From: Laura Gibbons <Laura.Gibbons@arun.gov.uk>
Sent: 31 August 2021 10:56
To: Planning.Responses <Planning.Responses@arun.gov.uk>
Cc: Michael Eastham <Michael.Eastham@arun.gov.uk>
Subject: WA/63/21/PL- Land East of Tye Lane Walberton BN18 0LU

Engineers Comments Regarding Surface Water Drainage/ Land Drainage

We object to the proposals for the proposed alternative vehicular access off Tye Lane.

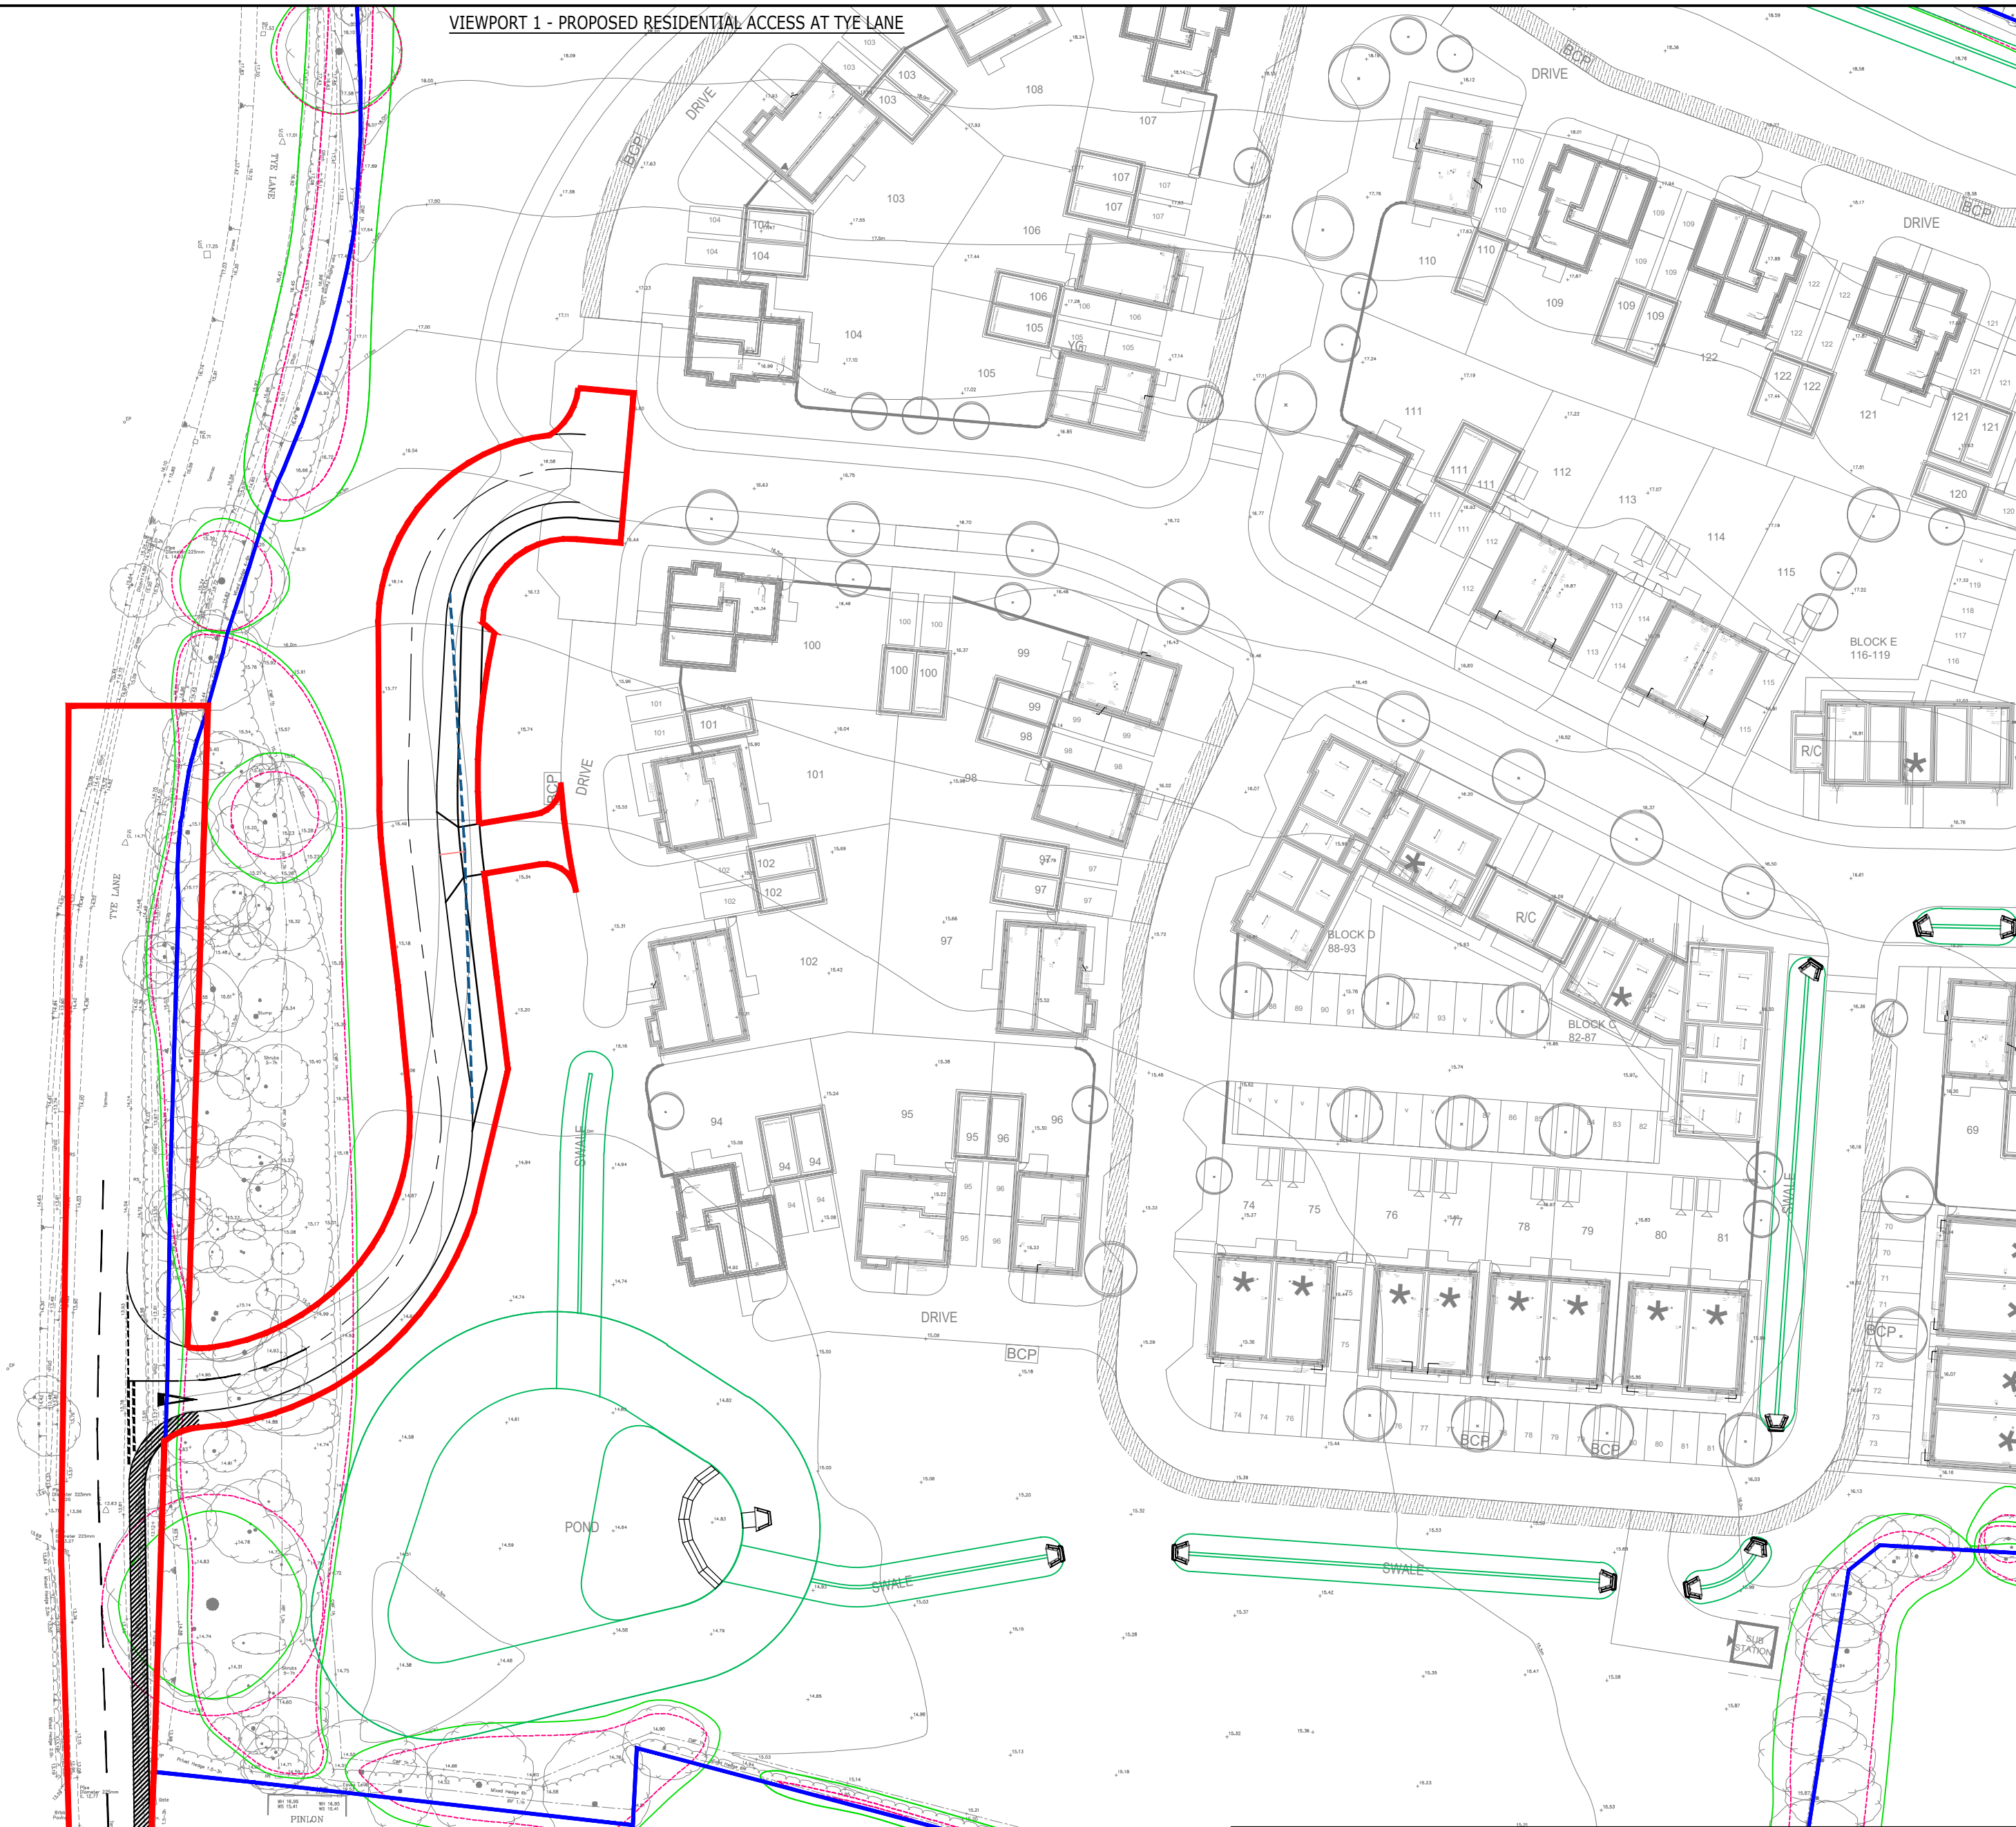
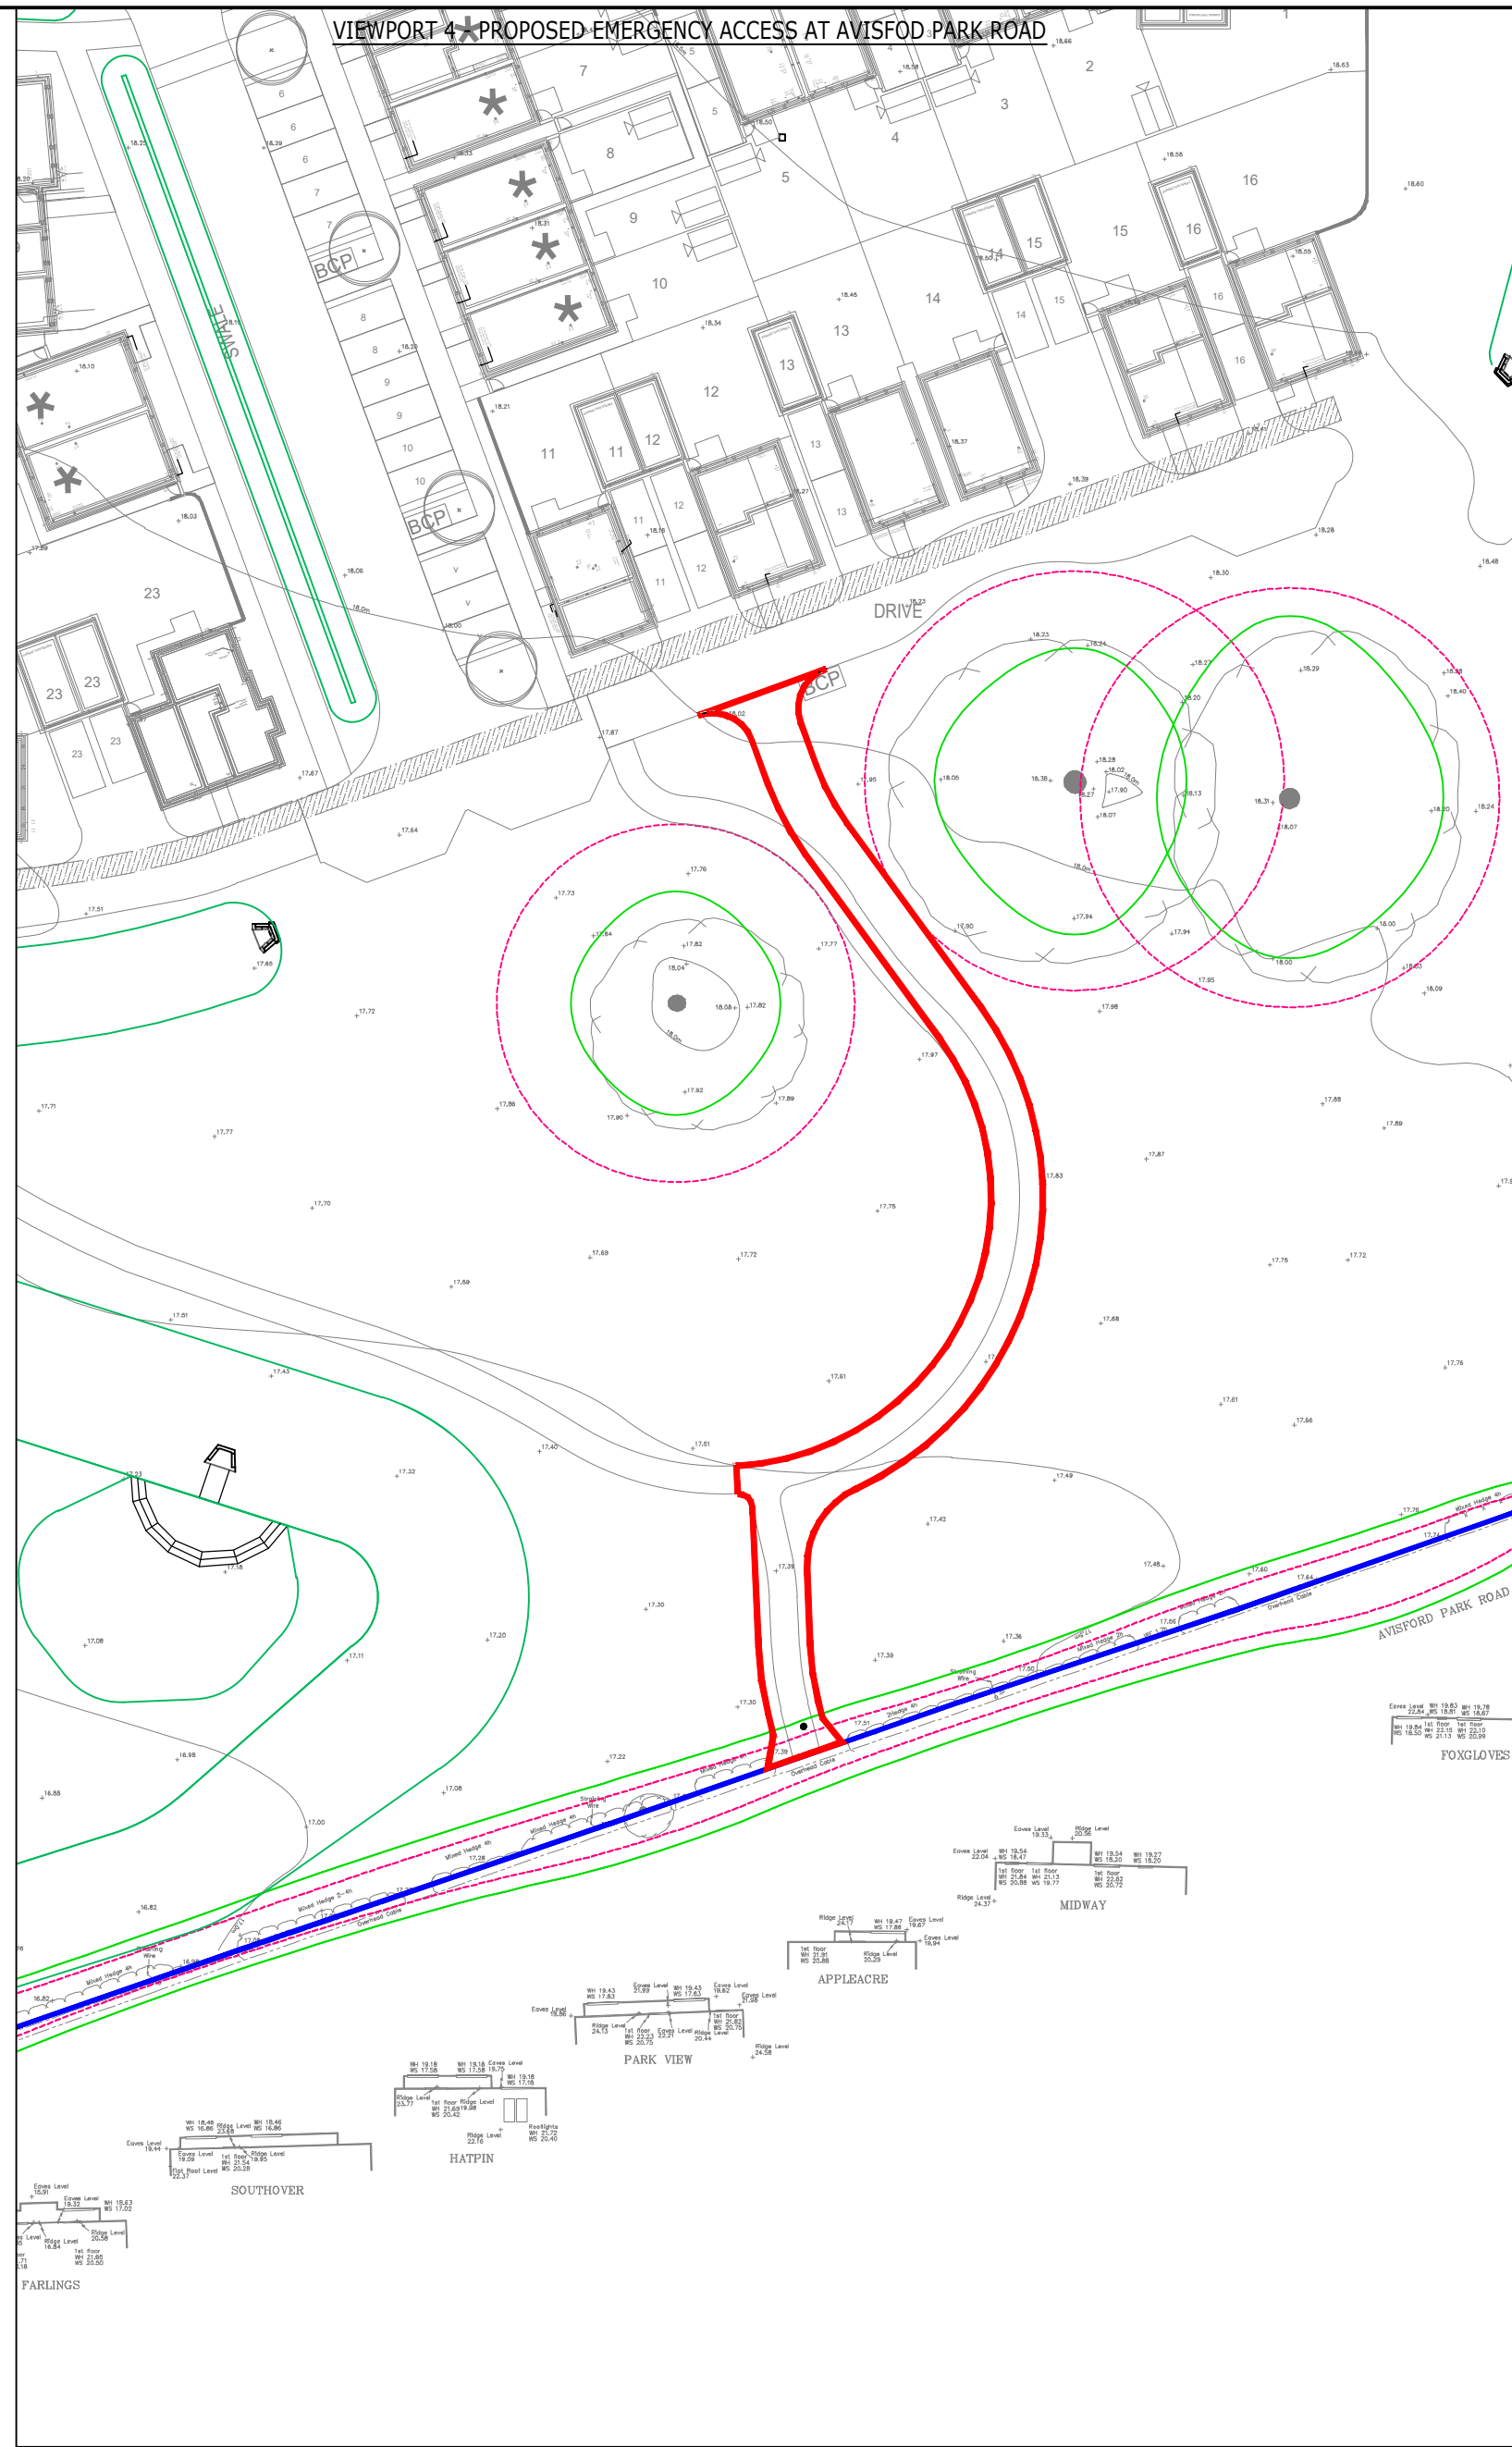
1. The new culvert has proposed upstream and downstream invert levels of 13.05 and 12.95 respectively. It is clear that there will be a clash between the proposed culvert and the foul pipe. The foul pipe has an I.L. of 12.8, with a diameter of 150mm, an external diameter of 188mm is typical, therefore this pipe will have a crown level of 12.988. It can be seen this is likely above the invert level of the watercourse culvert at this location, let alone the barrel level of the culvert and base level of the concrete surround. There is clearly a clash.

2. Proposals to provide the longer culvert rely upon deepening the watercourse, it is not clear if this will be possible with the constraints that exist.

3. In order to form a footpath along the east of Tye Lane it is proposed to divert the ditch. The supplied cross sections show:
 - a. The proposed cross sections are narrower than the existing cross sections and will therefore result in a loss of capacity.

- b. The proposed cross sections are proposed to have steep 1:1 banks. These banks are steeper than existing banks, it is unlikely that the proposals will provide a long term stable watercourse. Proposals will likely result in erosion and collapse or a need to engineer banks which could result in a loss of natural habitat.

- c. There is a line of TPO trees along the eastern bank of the watercourse, it is unclear how the new watercourse profile can be provided without damaging these trees.

In summary it has not been evidenced that the new access can be delivered whilst maintaining the free flow of water and capacity within the watercourse.
